Cambridgeshire County Council (20031358)

East Cambridgeshire District Council (20031149)

The Councils' Comments on the ExA's Schedule of Changes to the draft Development Consent Order (dDCO) [REP6-013]

Sunnica Energy Farm (EN010106)

### **I.1                      Works Plans**

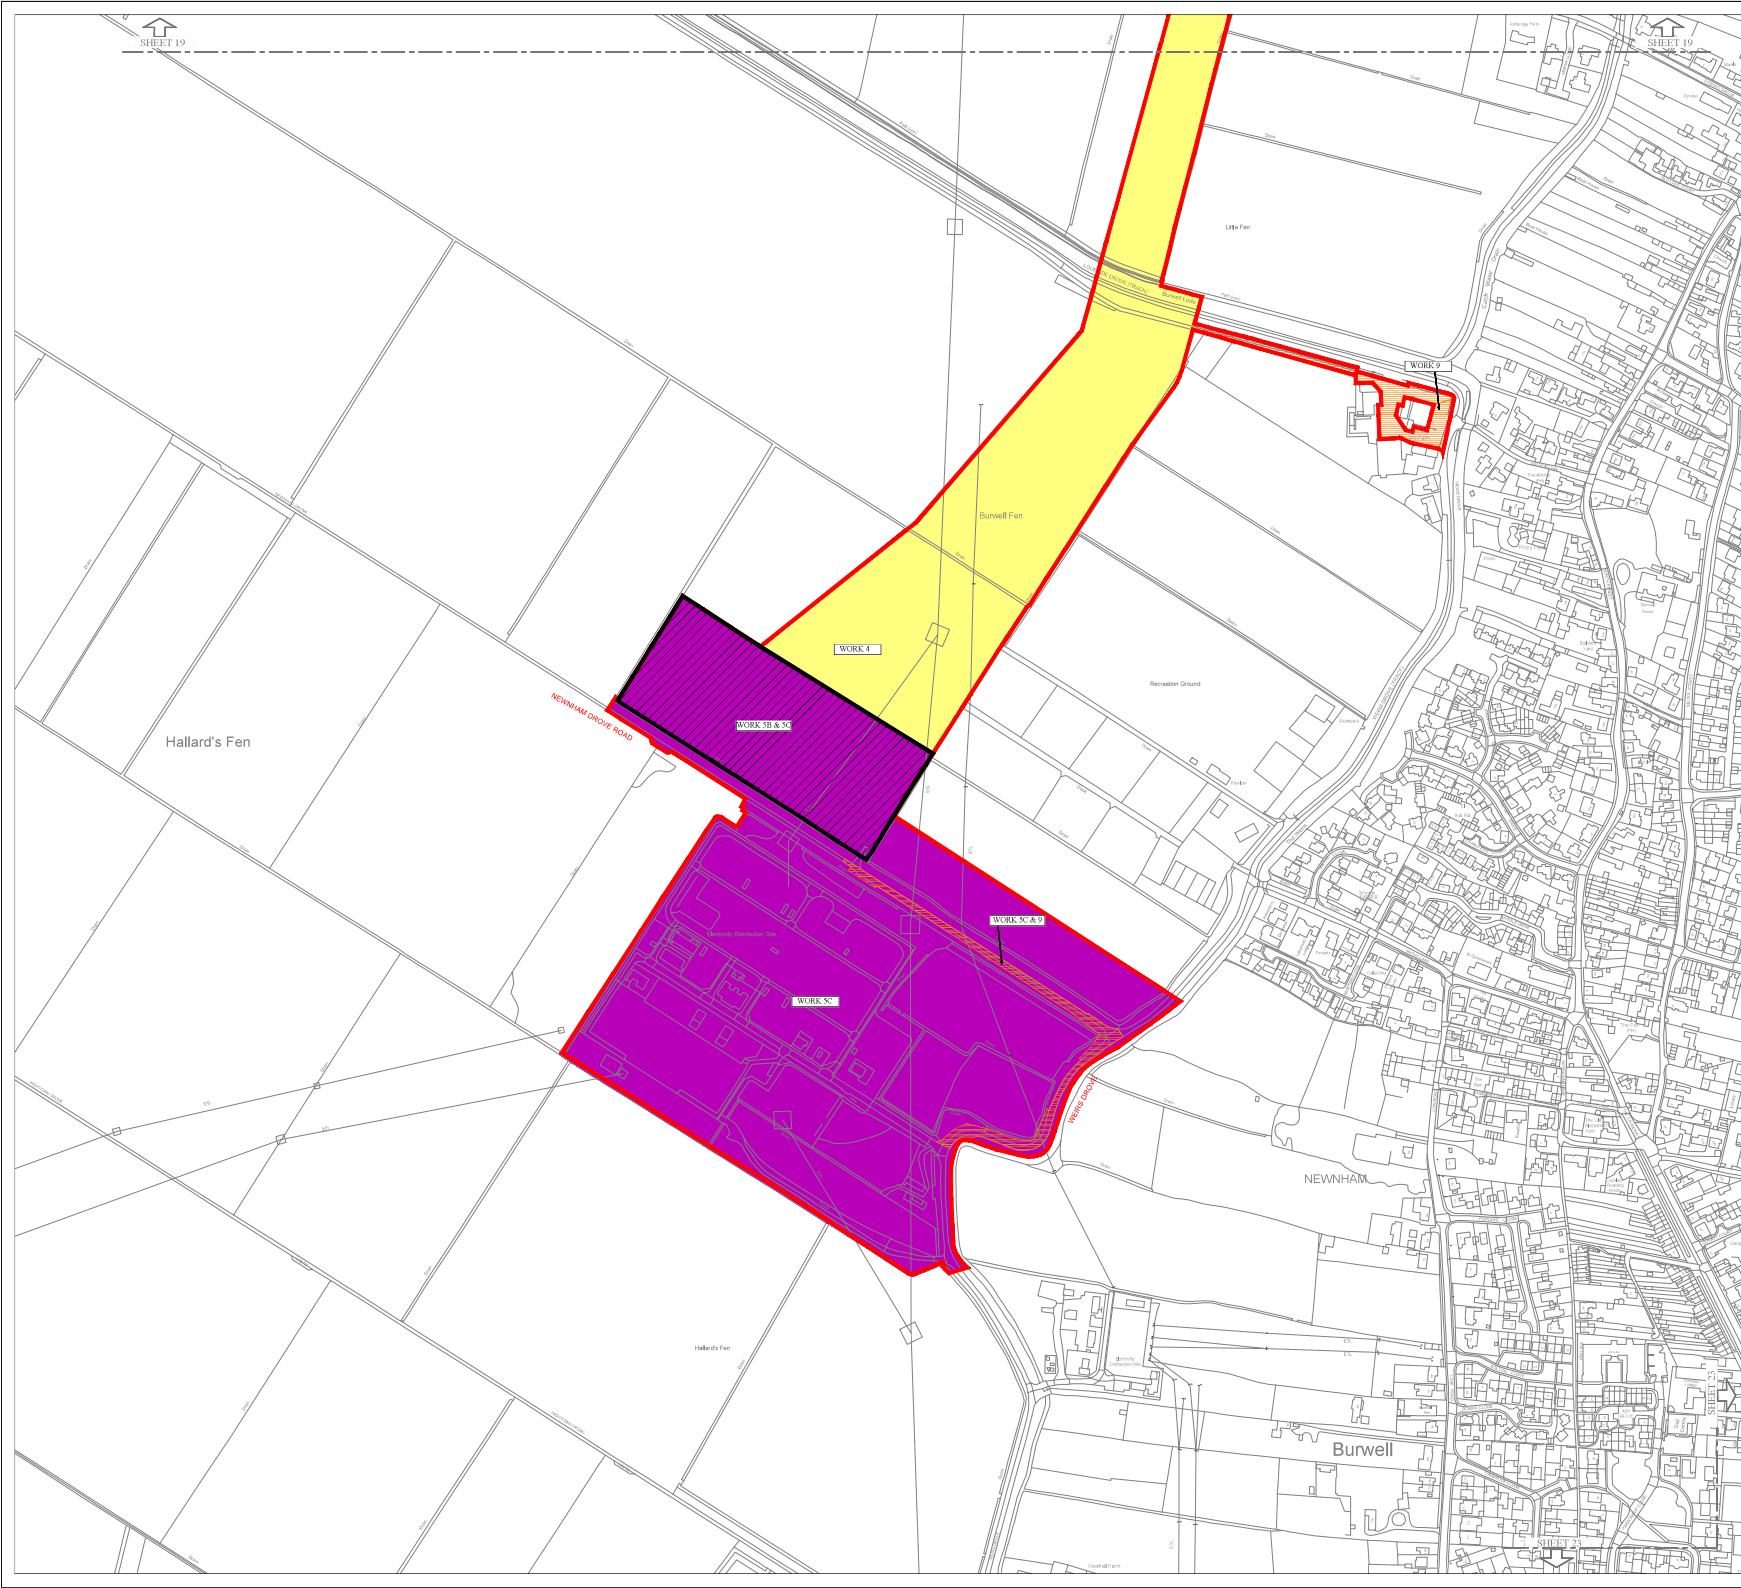
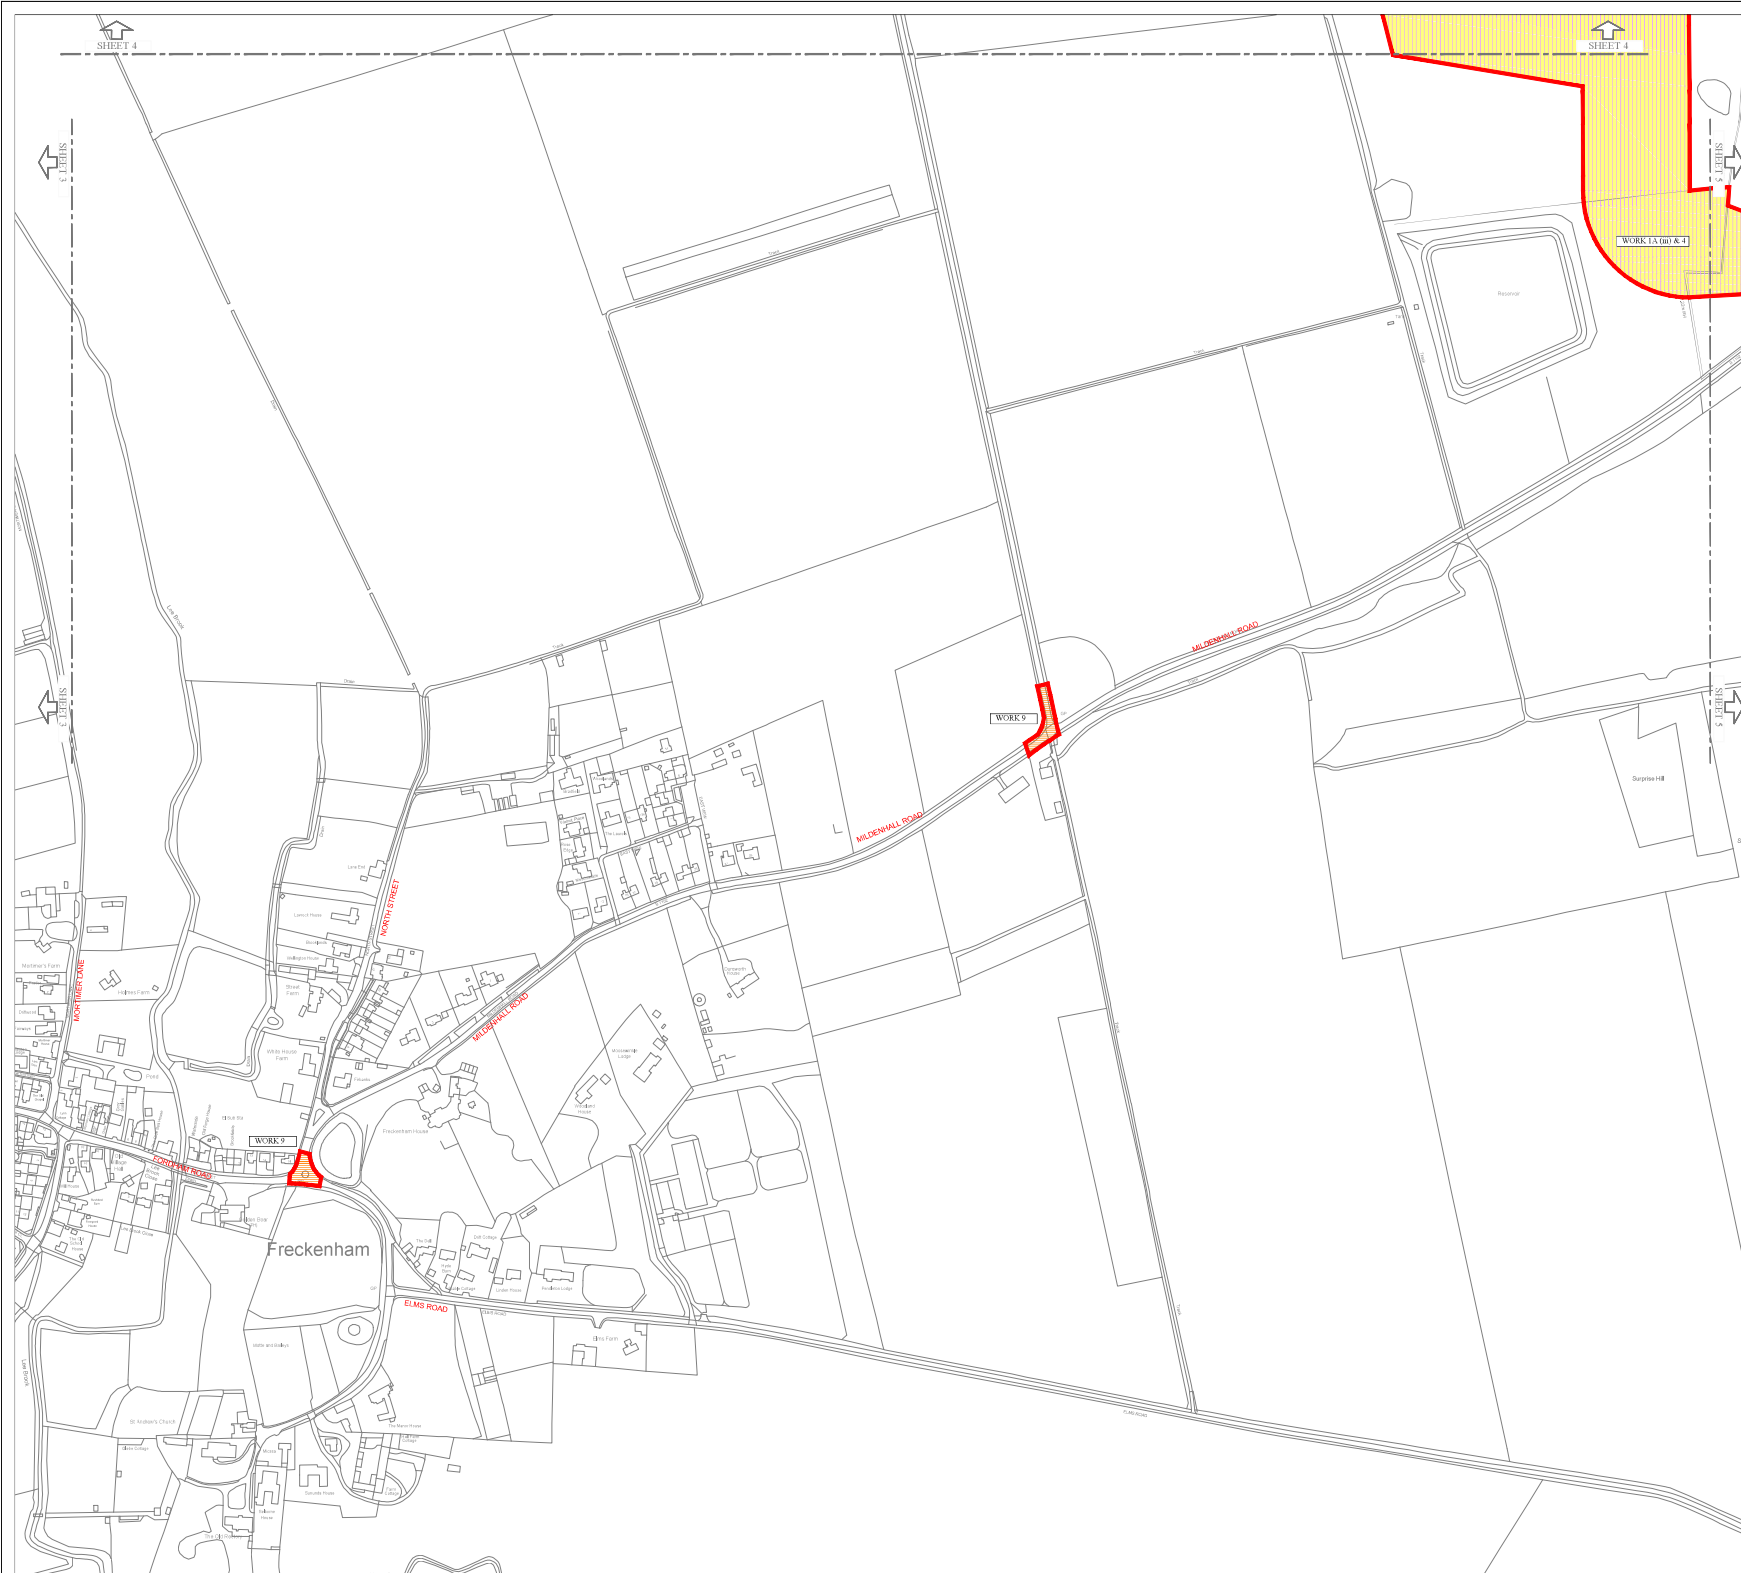
The Councils welcome the Examiner's approach, that Work No 10 can be removed ONLY if "*the remaining parts of the development do not require any stone curlew offsetting measures*".

The current Stone Curlew assessment and mitigation is based on the existing scheme. To date, there has been no detailed assessment to determine the level of impact on Stone Curlews and what mitigation measures including offsetting are required, should solar panels be removed from E05/E12/E13. In addition, the ECO areas are part of the embedded mitigation for the scheme as

designed (Environmental Statement at Section 8.8 [APP-040]), and any changes to these could also affect other species, habitats and Biodiversity Net Gain.

The Council considers that if the impact of changes to the scheme on Stone Curlews (and potentially other habitats and species) are unknown, the Rochdale Envelop should be applied as a precaution, it would be most appropriate to retain Work No. 10 in the DCO. The level of offsetting proposed within the Stone Curlew Habitat Offsetting document will be able to adapt in order to reflect any changes to the scheme.
